Rezoning Petition Review

Rezoning Petition #: 21-025

Location of Property: Approximately 13.05 acres located along the north and south sides of Wallace Lane and east of the East Independence Expwy.

RZ-1.0

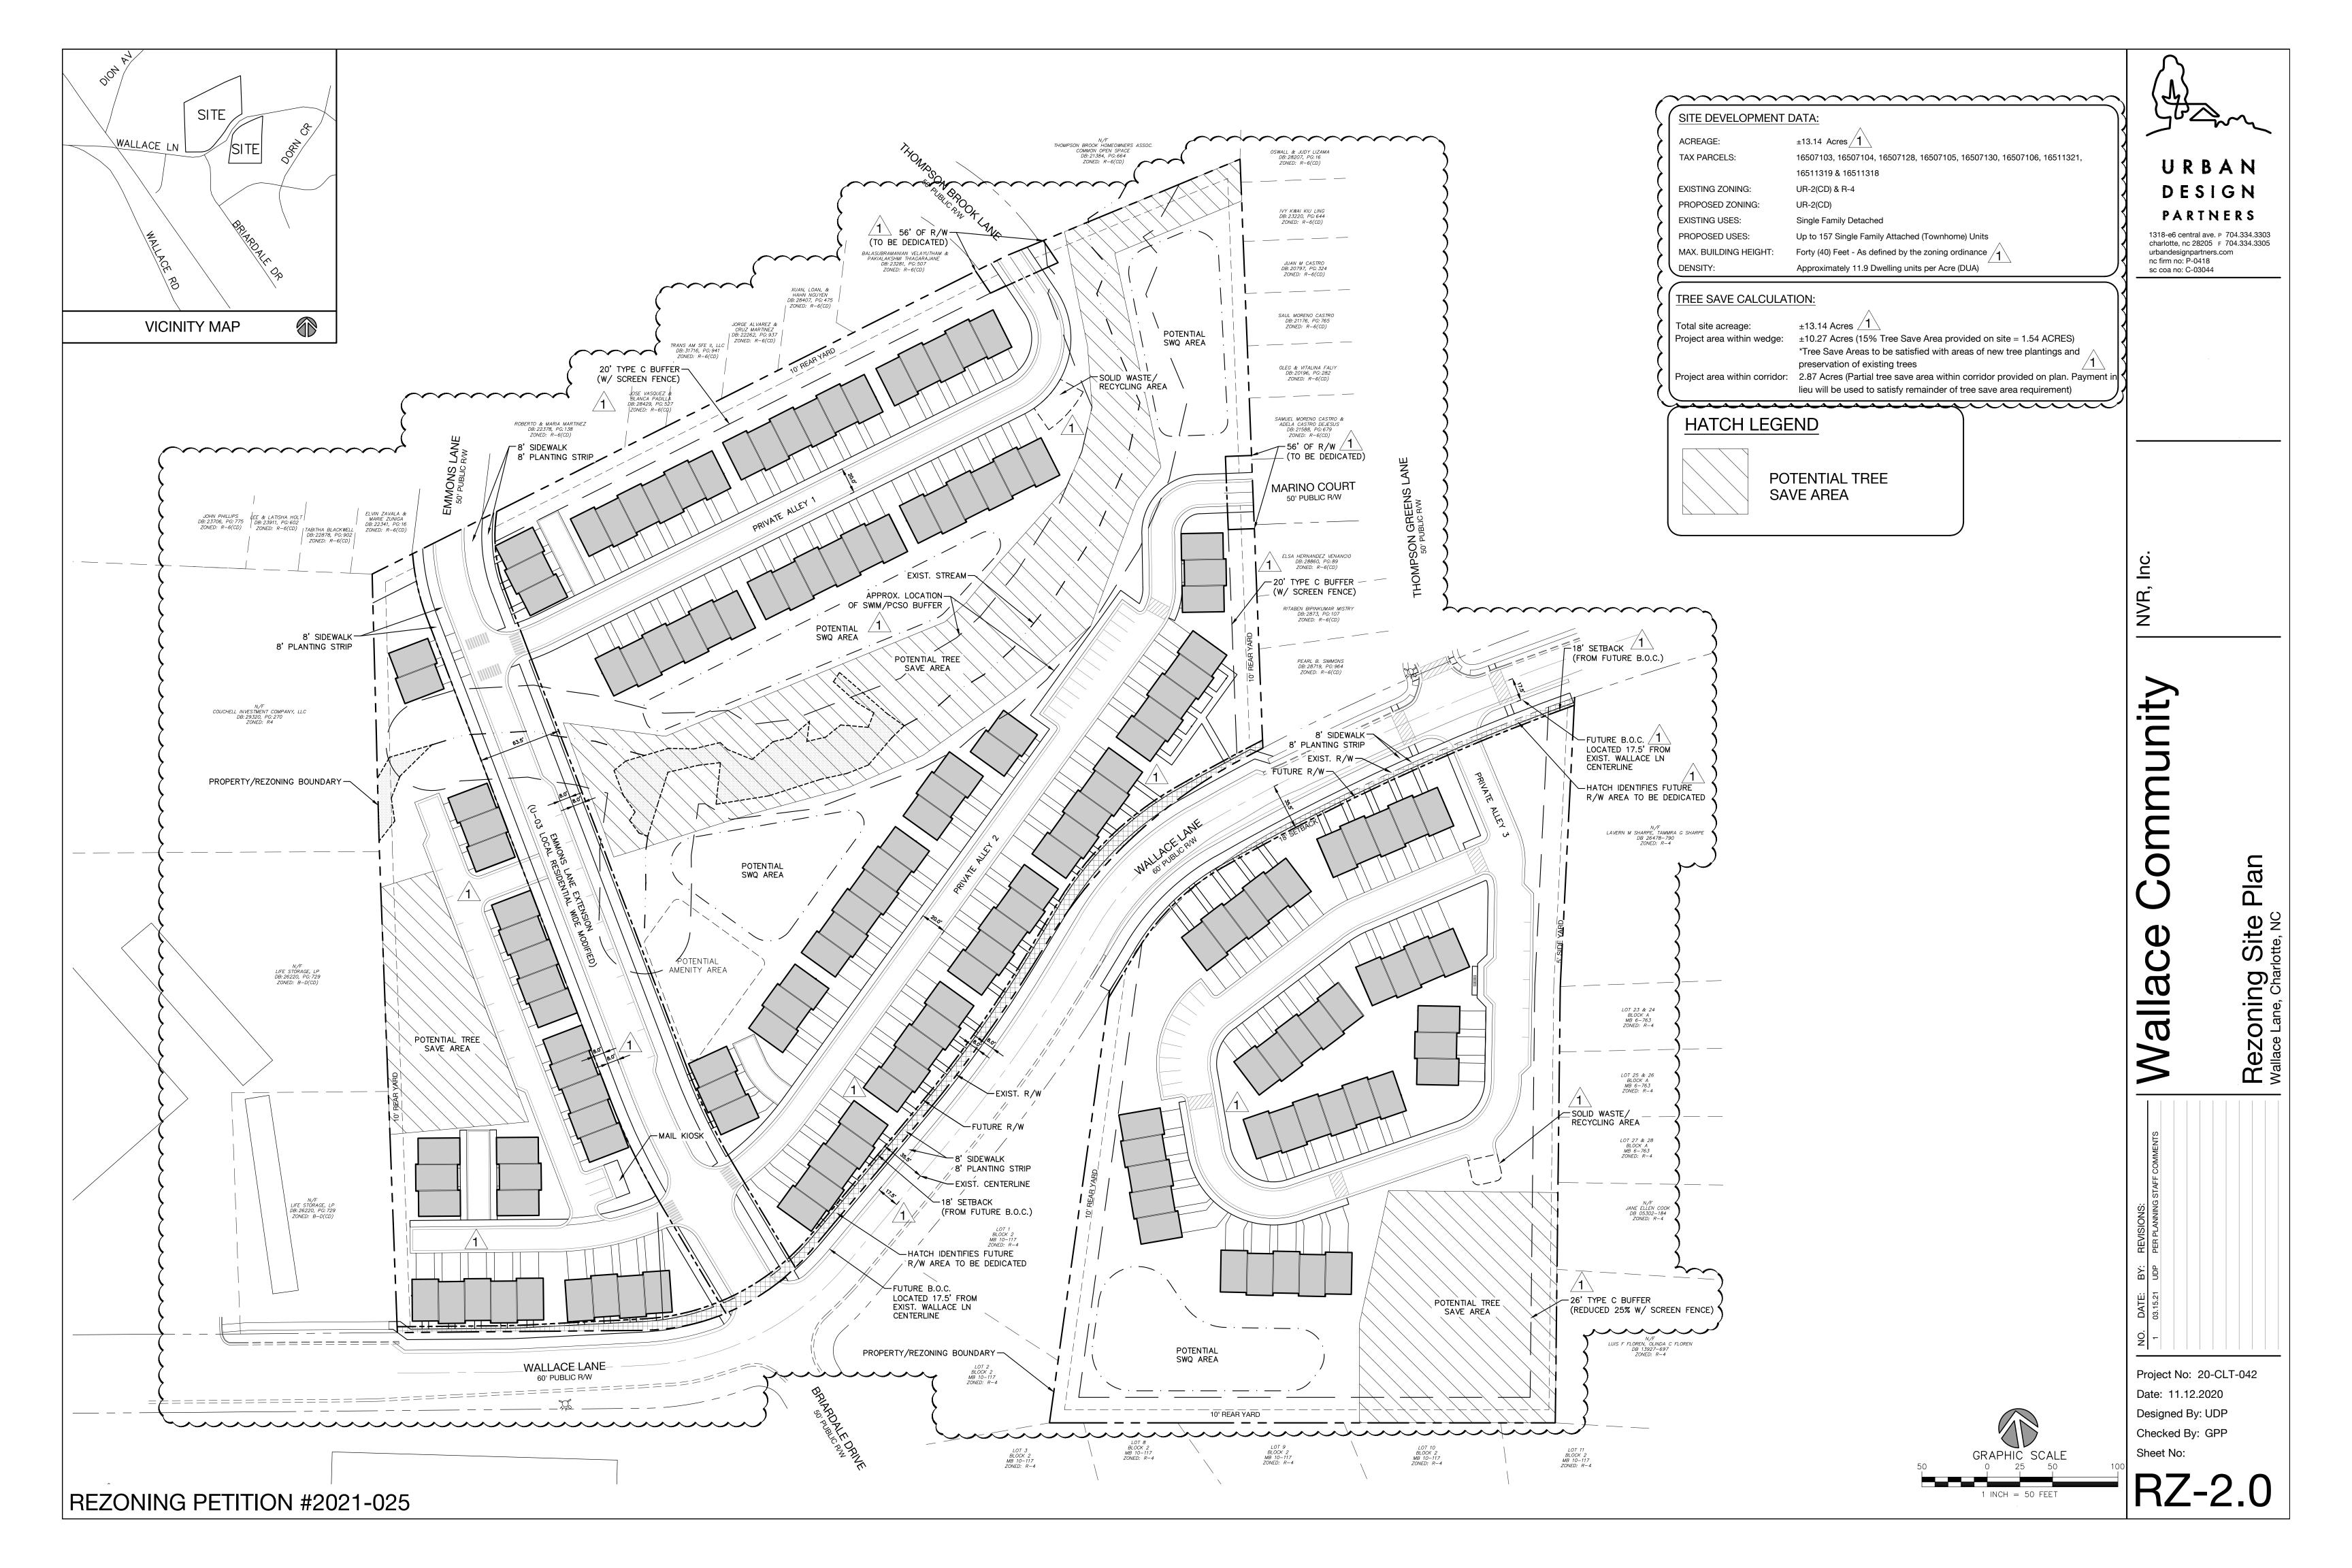
Downstream properties have open Storm Water requests for service. Please include the following note under Environmental Features:

- *The following shall apply to the portion of the development south of Wallace Lane: For adjoining parcels receiving storm water discharge the petitioner shall analyze the adequacy of the existing storm water conveyance on the adjoining parcels to Maplecrest Drive. If the existing storm water conveyance on the adjoining parcels is found to be inadequate, the Petitioner shall make a good faith effort with the property owner(s) to improve the storm water conveyance or mitigate the storm water discharge onto the adjoining parcels.*
